MMO Reference: DCO/2024/00007
Planning Inspectorate Reference: EN070009
Identification Number: 20049273

16 September 2024

**Planning Act 2008, H2 Teesside Limited, Proposed H2 Teesside Order
Deadline 1 Submission**

APPENDIX 1: FIGURES 1-4

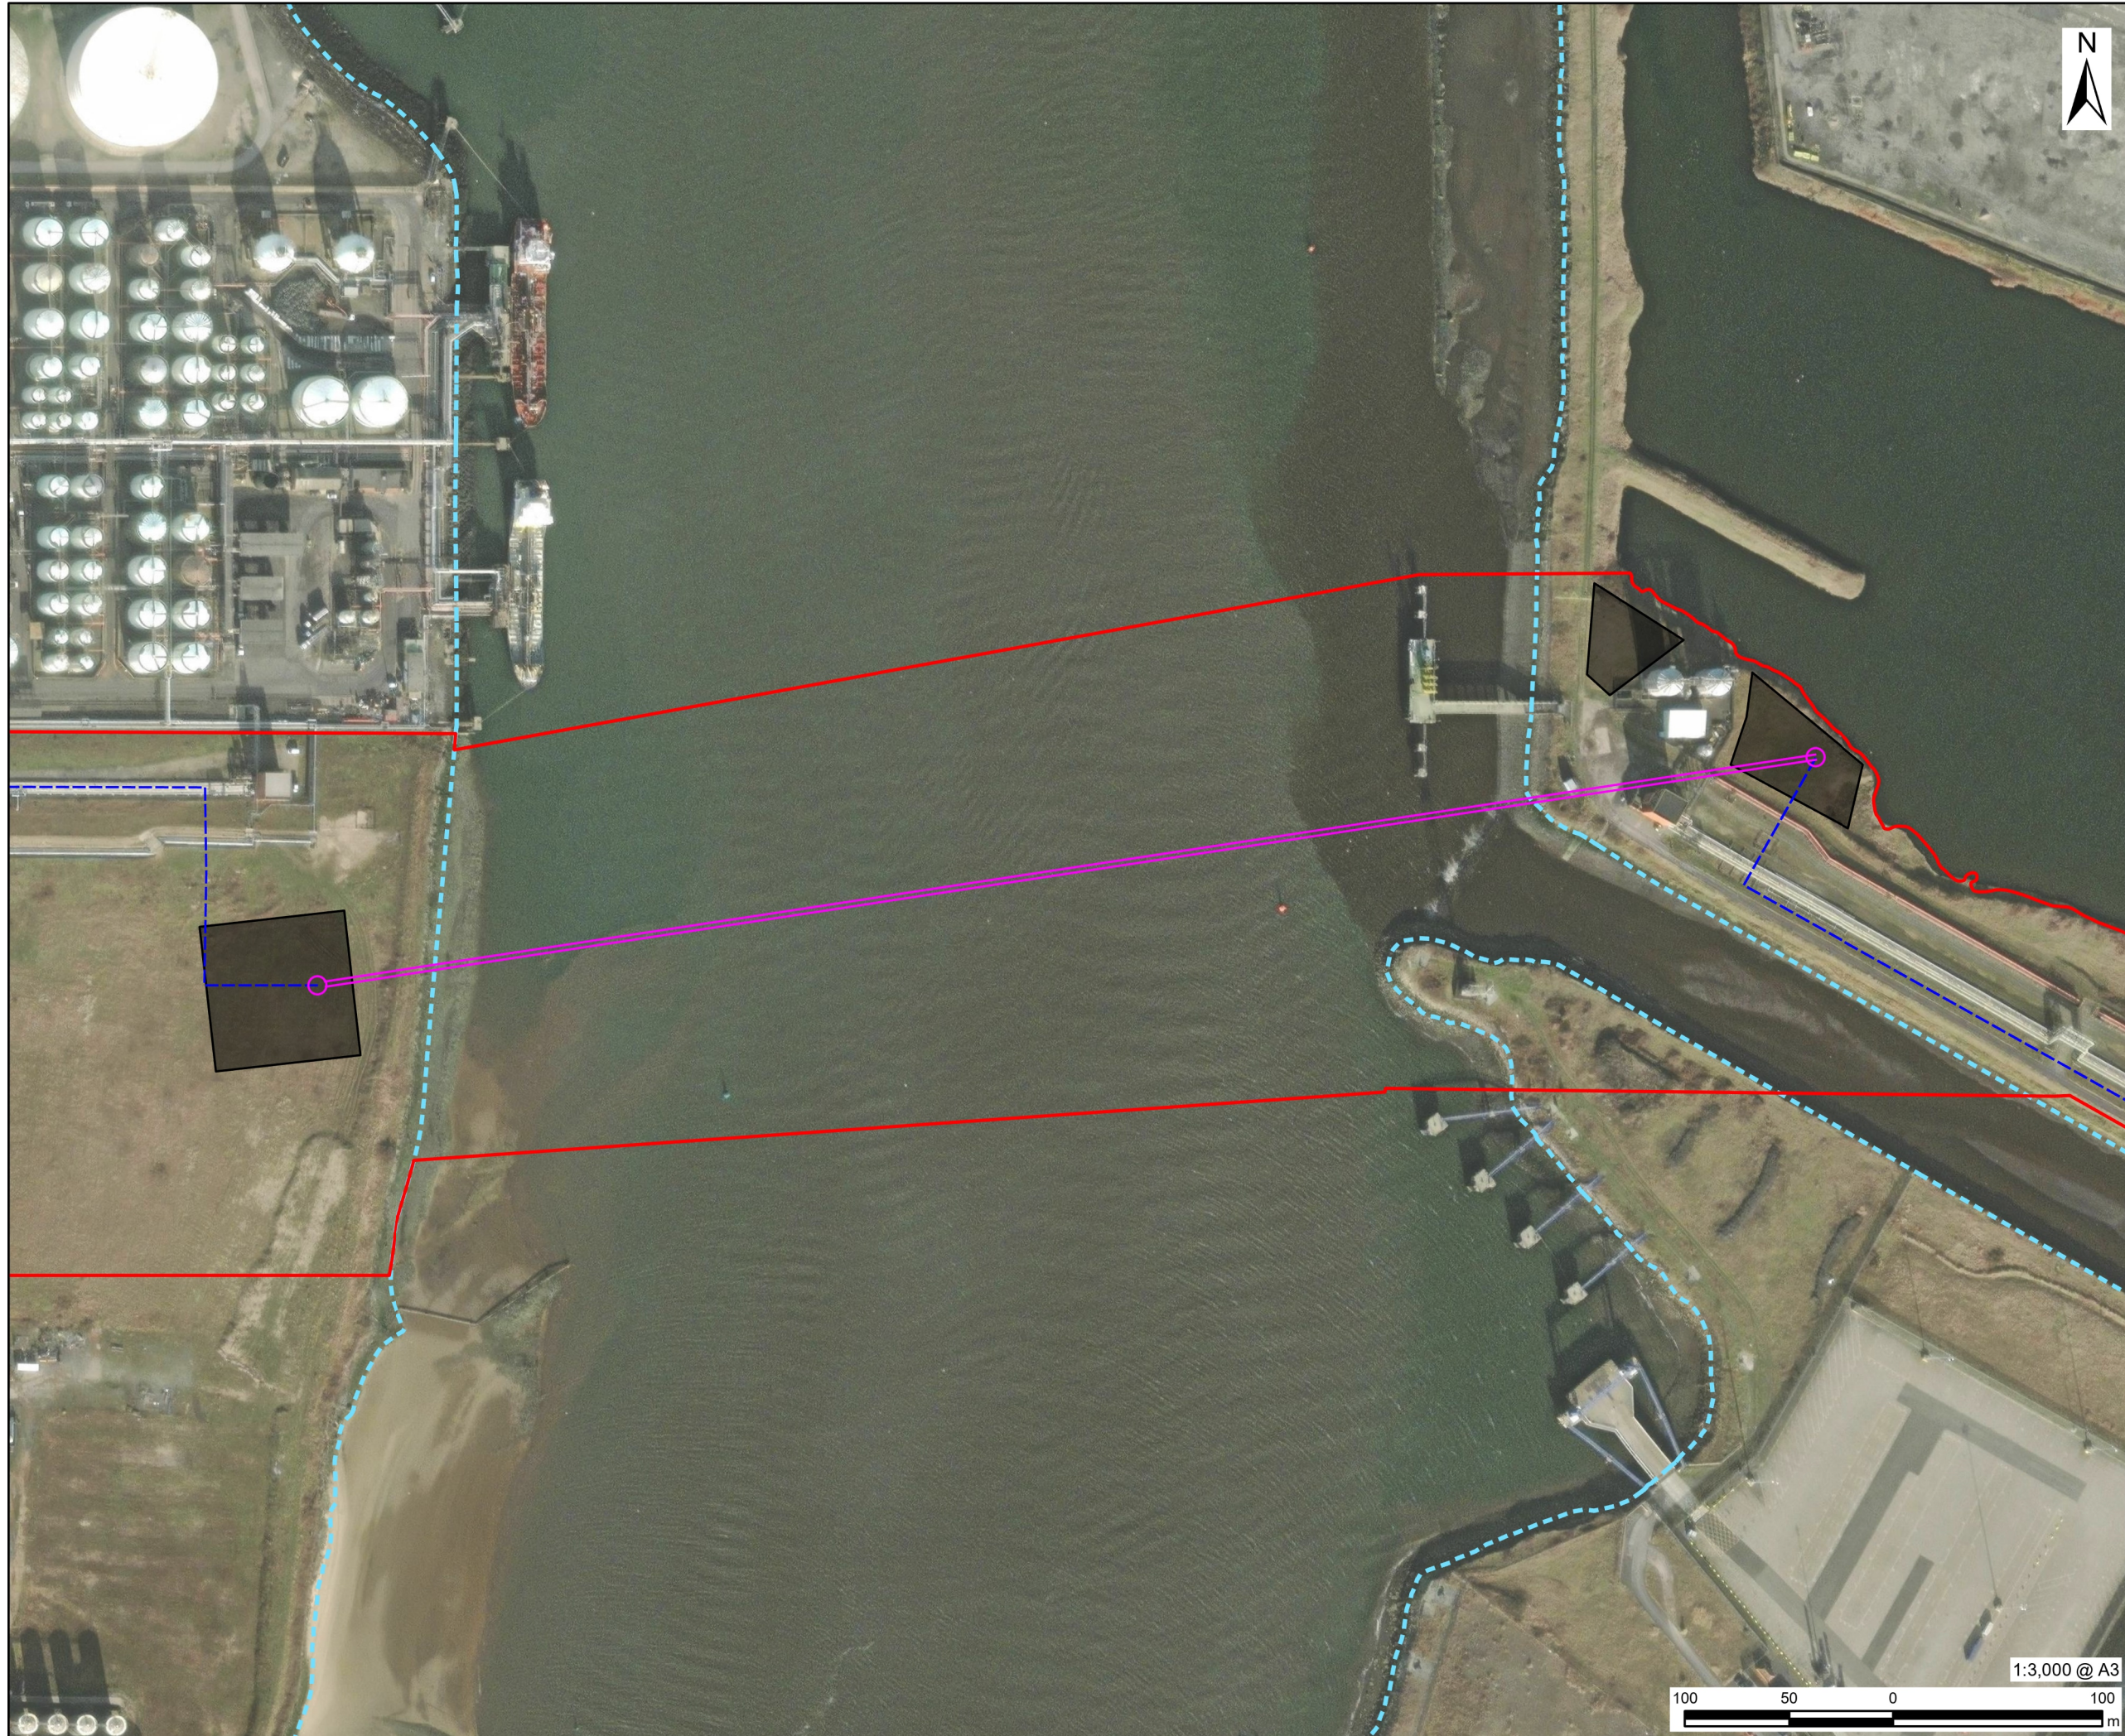
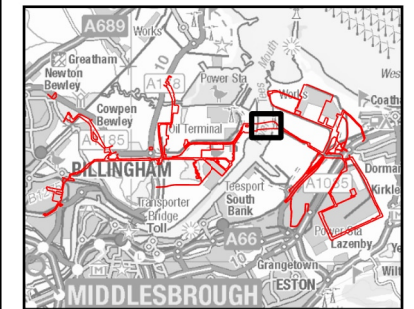
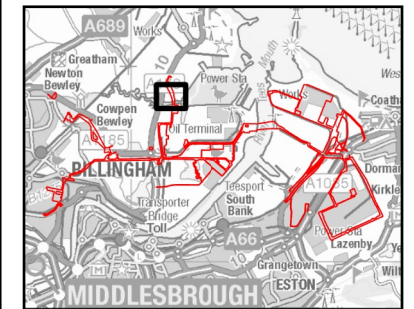
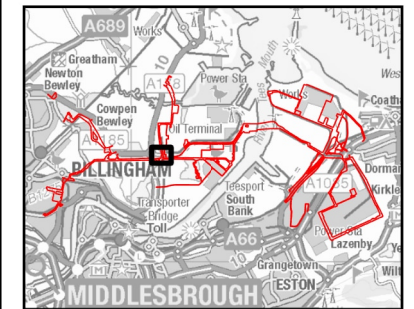
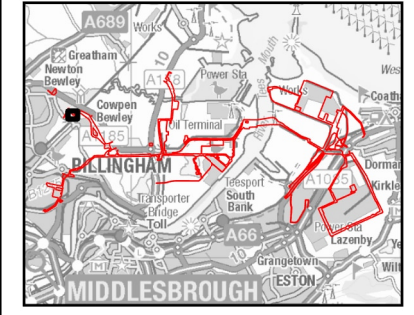
2.2.2 It is not stated within the ES where the entry and exit points of the tunnels are expected to be in relation to the limits of the marine environment. The Applicant has provided MMO with a map detailing the exact locations of the entry and exit pts, and the MMO is satisfied that these are sufficiently above MHWS. The Summary of Effects chapter indicates that launch pits will be outside the SPA, SSSI and RAMSAR boundaries.

The MMO has now received a map detailing the entry and exit pits for the trenchless crossings from the Applicant, and notes that the ExA is seeking the same information (Question 1.15.6). This is attached to Annex 1. Whilst the MMO is content that the pits are above MHWS, we would like to see the distances referenced to the MHWS mark, to understand whether the pits are at a sufficient distance away from marine receptors. The MMO also queries what data set has been used to obtain the MHWS mark.
